Recommendation Report for Planning Permission

REF NO:	LU/247/20/PL
LOCATION:	57 River Road Littlehampton BN17 5DD
PROPOSAL:	Partial demolition of existing building, retention of boundary wall & street facade, partial demolition of boundary wall to incorporate new pedestrian gateway & gate, erection of 6 No. flats in 2 blocks connected by shared stair & lift core, on site parking yard for 8 No. cars & 8 No. cycles & space for communal refuse & recycling bins. This application affects the character & appearance of the Littlehampton River Road Conservation Area & is in CIL Zone 4 (Zero Rated) as flats.

1908-P-400-2 RIVER ROAD ELEVATION

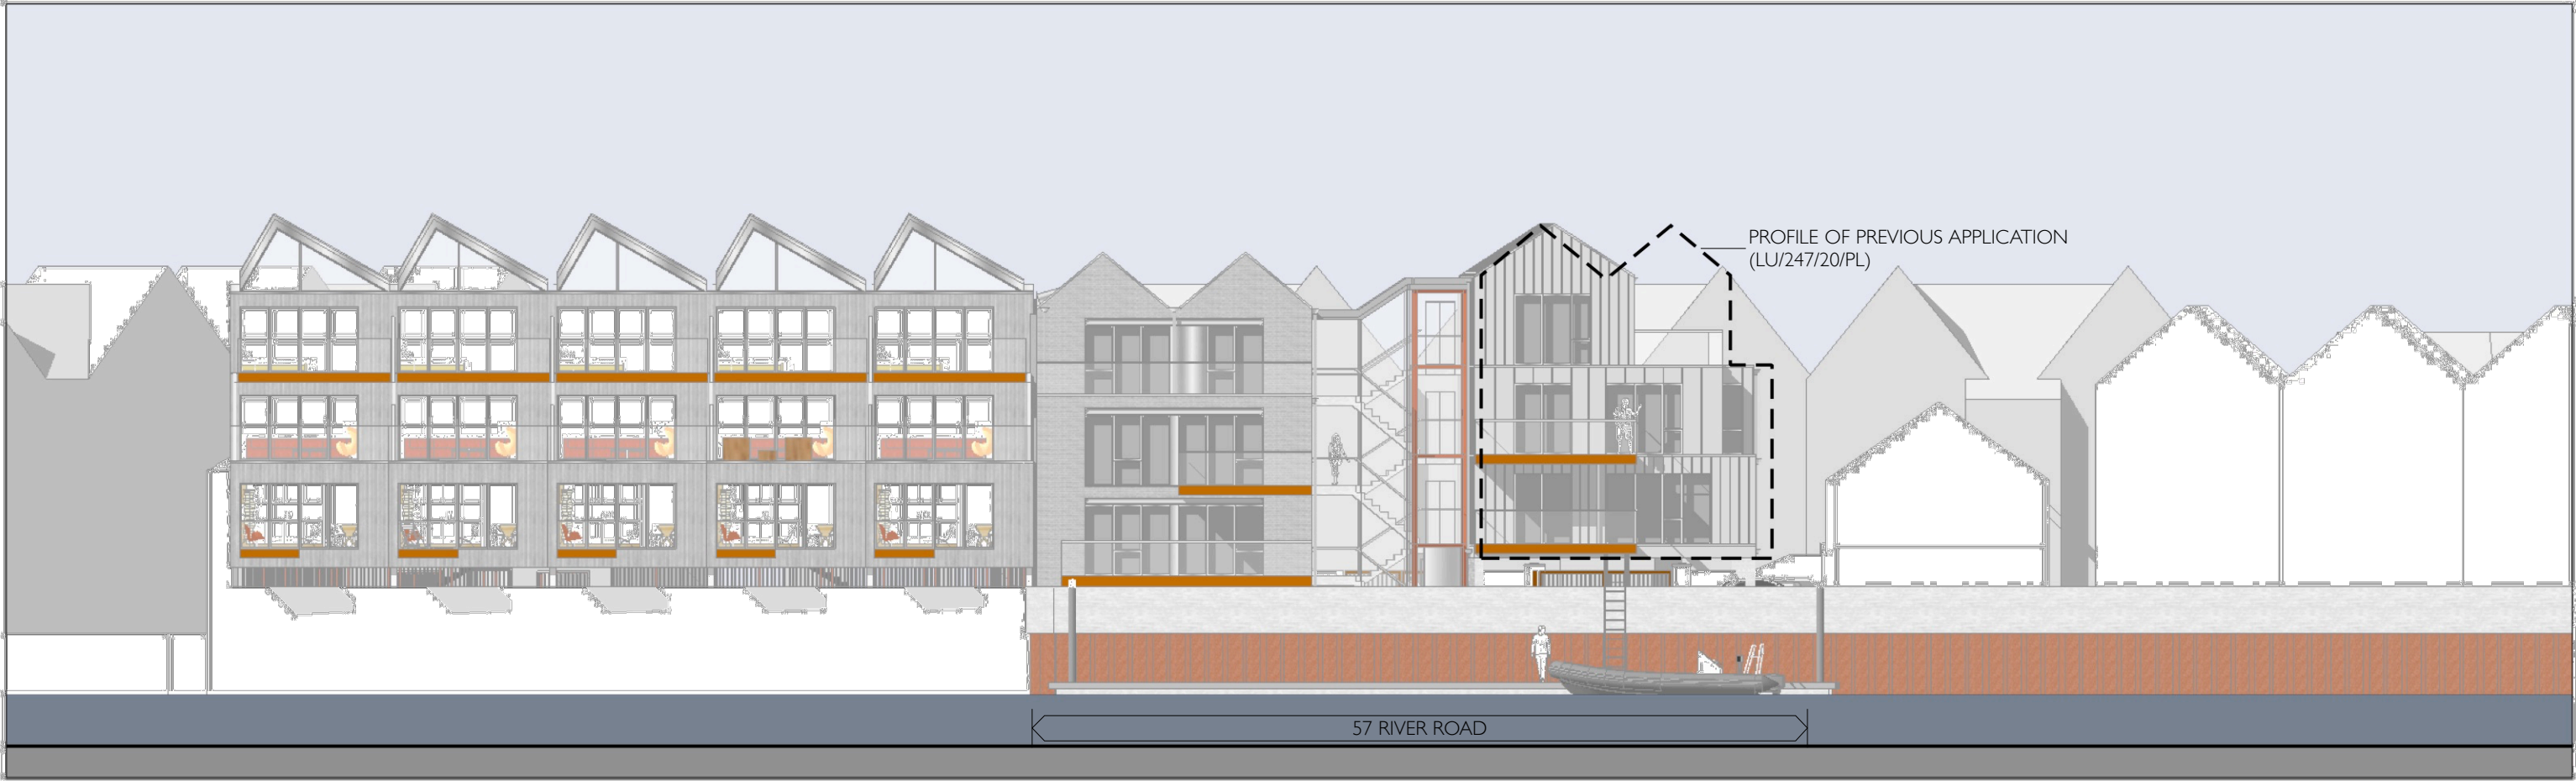
In terms of impact on the character of the local area the southern block is one floor too high. The proposed development at this height would negatively impact on the setting of the neighbouring asset.

With the exception of the most southerly unit the massing of the 2 buildings sits comfortably within the street and river scene. River Road is relatively narrow making the oblique views along the street important visually. Both buildings have set back top floors with terraces. The southerly block also steps back at second floor along the south east boundary, but the height, combined with distance to the southern boundary does not respect the scale of 49 River Road and it is overly high in relation to it. No assessment of this dominating impact on the adjacent Building of Character has been provided.
